Online Comment

Application H17-0021-24
Location 10 Gosberton Road Surfleet Spalding PE11 4AB
Proposal Residential Development of up to 4 dwellings

Name Greg Watkinson
Address Conservation Officer

Indicative Front Elevation
Scale 1:100

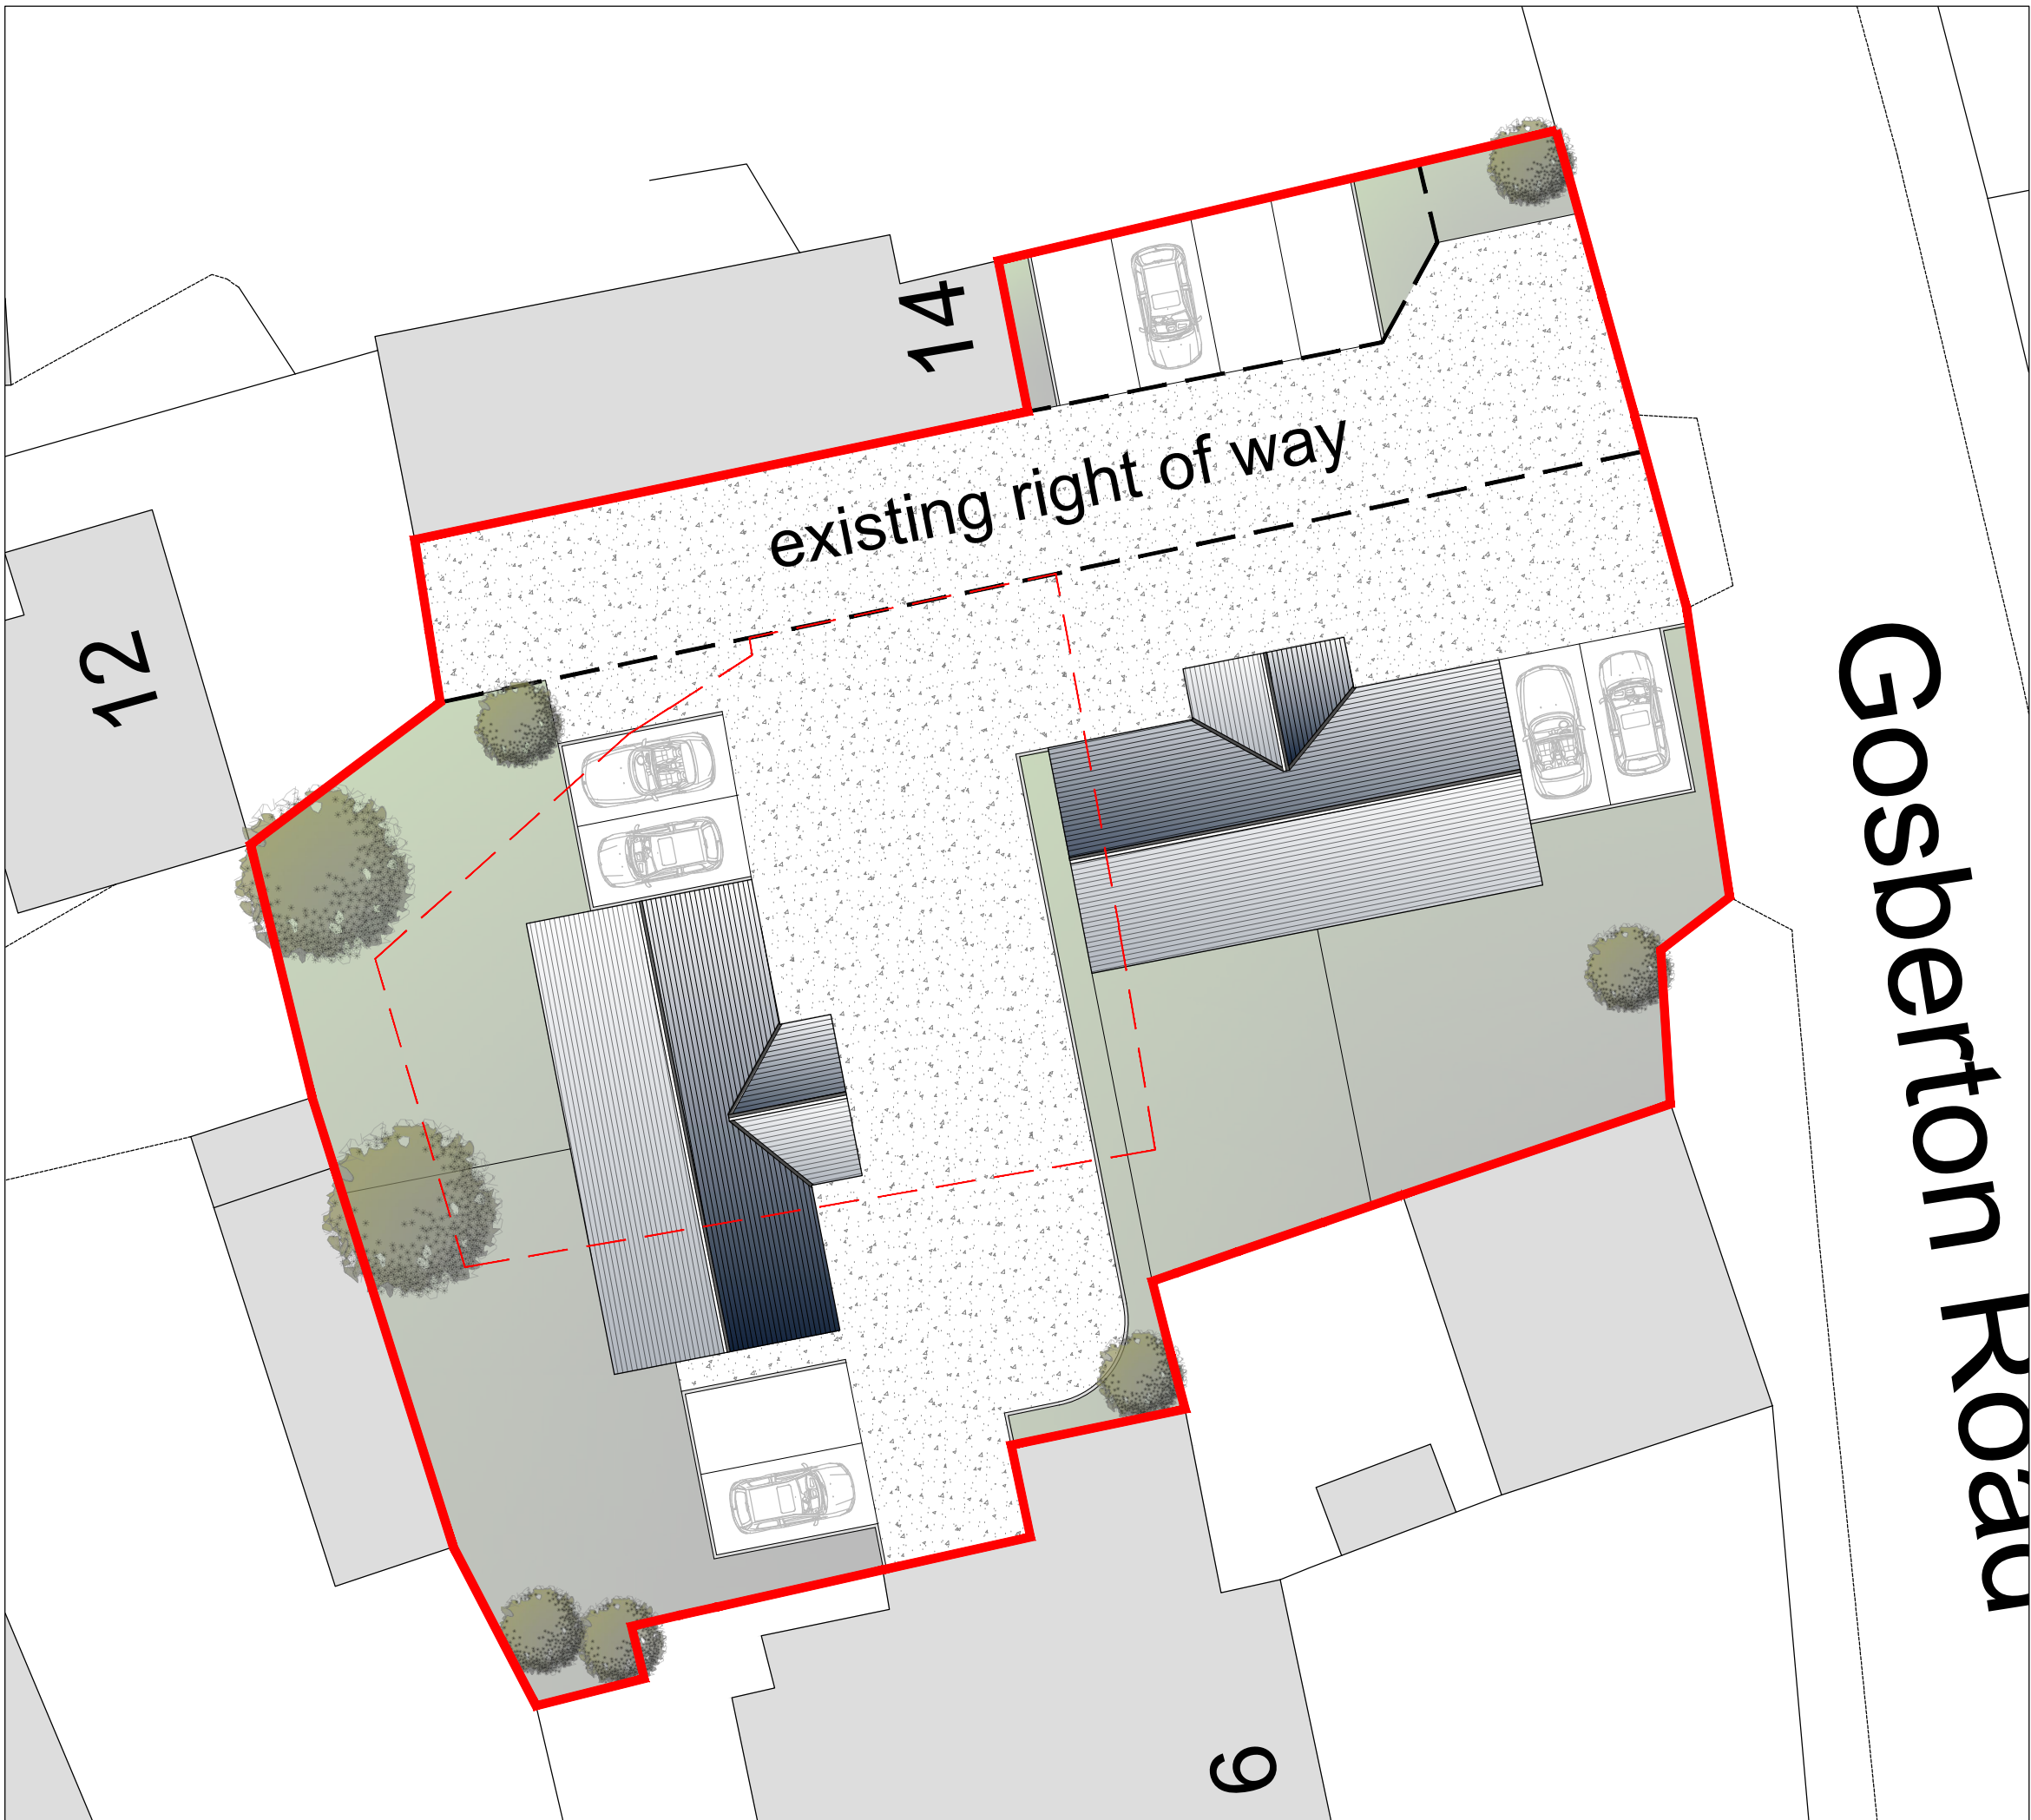
It is recognised that, because this proposal is outline at this stage, the indicative elevation provided is purely indicative and not necessarily representative of that which shall be proposed at the Reserved Matters stage. Moreover, the site as extant does not represent a positive force upon the appreciation of the local historic environment. However, the proposal is situated in the very centre of the historic village of Surfleet, positioned in close proximity to numerous late C18th and C19th properties, several of which could be considered Non-Designated Heritage Assets. As such, I would suggest that the applicant be made aware that the indicative elevations provided appear too plain and lacking in sympathy with neighbouring development. Regardless of the lack of a conservation area, the reserved matters should be seen as an opportunity to improve the qualities of the village, and therefore a high quality of design will be an expectation of the final proposal, in order to satisfy Policies 2 (paras 2 & 9), 3 (para 1) and 19 of the South East Lincolnshire Local Plan (2019).
